Consultation Response from: KC Environmental Health (Pollution & Noise Control)

2020/92553 - 7 Cherry Tree Centre, Huddersfield, HD1 2ET

Change of use of 1st floor office to one residential unit (within a Conservation Area)

**Responding Date:
11 June 2021**

FIRST FLOOR PLAN

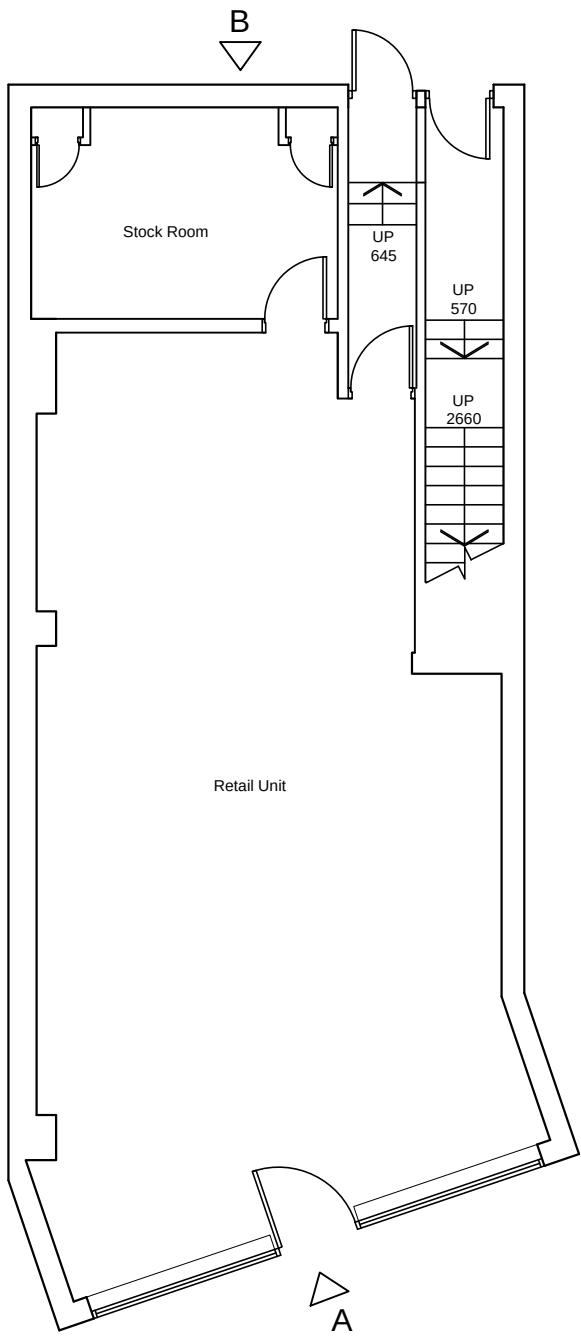
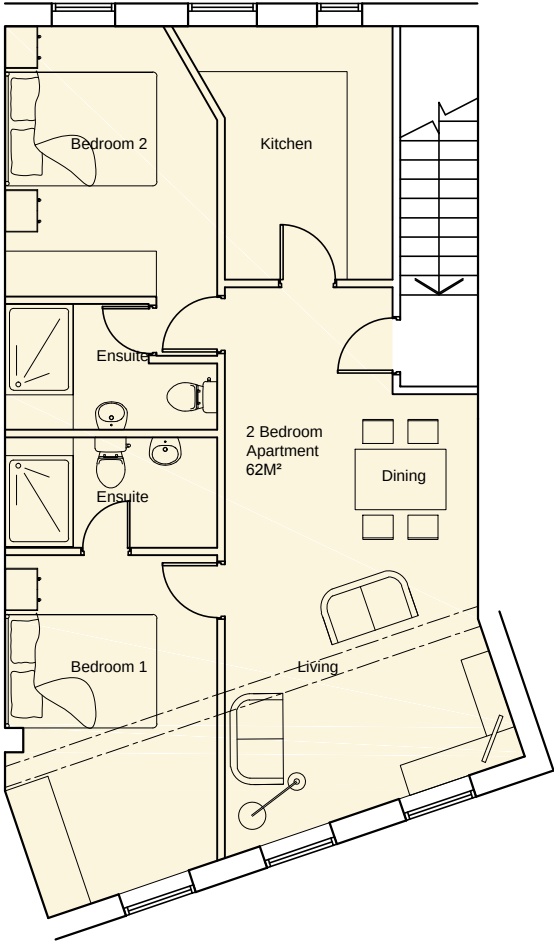
The report makes reference to the ANC Acoustics Ventilation and Overheating guidance stating a Stage 1 risk assessment would indicate the front living and bedroom spaces are expected to be at a medium risk and rear living and bedroom spaces are expected to be at negligible risk from disturbance by road traffic noise when windows are open. It goes on to say that there is no reason why windows cannot be opened for purge ventilation or personal preference and should therefore remain openable. However, in doing so, the occupiers would be exposed to a high level of noise. Acoustic trickle ventilation alone is unlikely to provide sufficient ventilation to help control thermal comfort without the need to open windows and would therefore not be acceptable and so alternative ventilation will be required to the front facade. A condition is recommended in order to protect the amenity of future occupiers.

The findings of the report show the party floor surfaces between the 1st floor proposed residential and the ground floor retail indicates a performance of 48dB $D_{nTw+Ctr}$ which meets with the required standard of 43dB $D_{nTw+Ctr}$ where the ground floor premises is used for typical retail shop purposes. However, if a restaurant, bar, café or other noisier businesses are considered for the ground floor space, then a further enhancement in performance would be required.

NC7 Ventilation of habitable rooms if windows need to be kept closed - Condition

Before construction commences, a ventilation scheme for rooms where windows need to be kept closed to prevent excessive noise levels shall be submitted to and approved in writing by the Local Planning Authority. The ventilation scheme shall provide the following information –

- Identify which rooms of which plots referenced back to the approved Noise Assessment require a ventilation system
- The acoustic specification of the proposed ventilation system demonstrating that when operated it will not cause indoor noise target levels to be exceeded
- The ventilation Scheme must demonstrate how habitable rooms of the development shall be provided with sufficient ventilation to help control thermal comfort and avoid over heating during hot weather without the need to open windows. This should include details of the air intake location and any summer bypass for any heat recovery system including a calculation for air changes/hour. A Standard Assessment Procedure (SAP) assessment would be acceptable to demonstrate that a risk of overheating is minimised.
